Drafted 27 March 2012

**Planning Applications, Ribble Valley District
3/12/0163 84-86 Lowergate, Clitheroe**

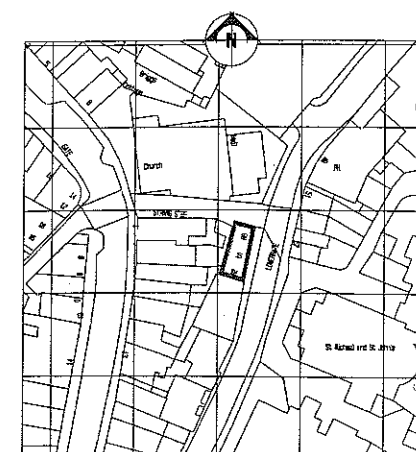
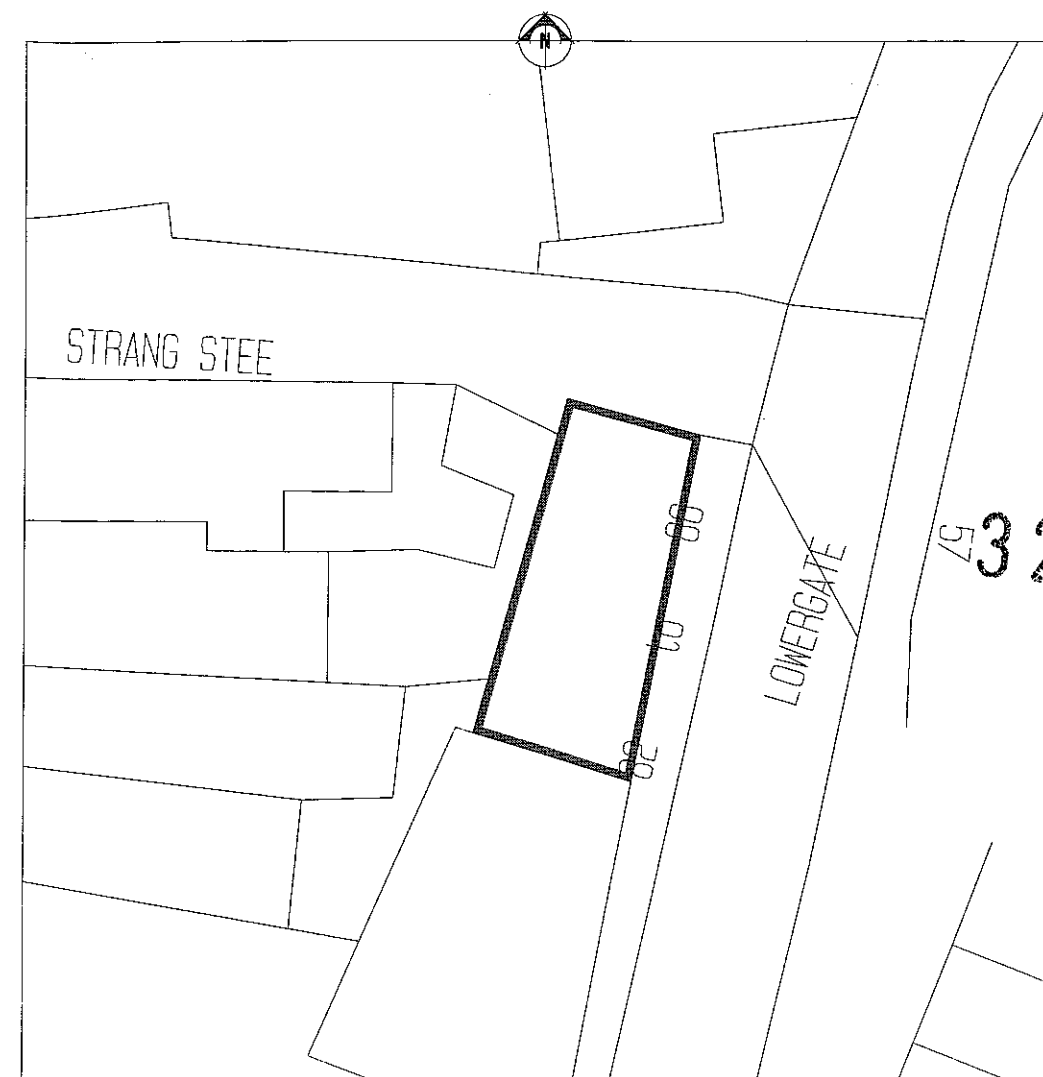
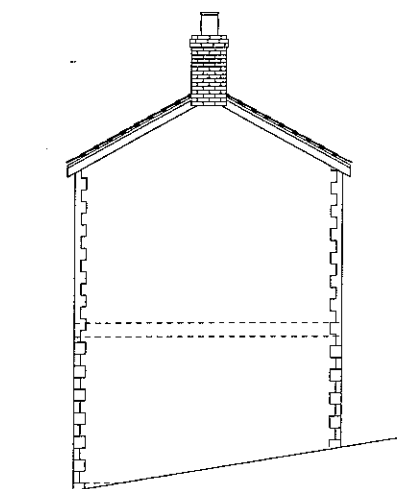
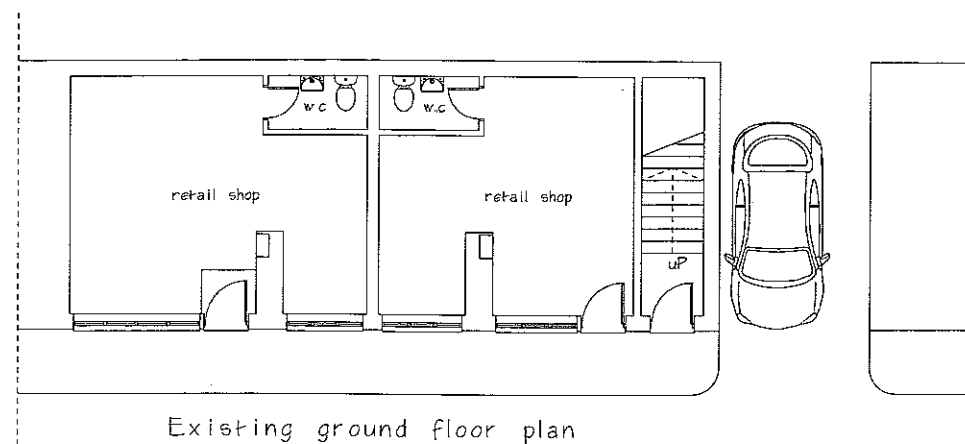
However, I noted that the site plan appeared to indicate a vehicle located on Strang Stee. This is not a suitable location for parking a vehicle as it would obstruct through traffic and be a potential hazard to pedestrians.

In view of the development's town centre location, the proximity of pay and display car parks and the accessibility of the nearby Clitheroe bus and rail interchange, there are a range of options for convenient alternative parking and access to the site by public transport.
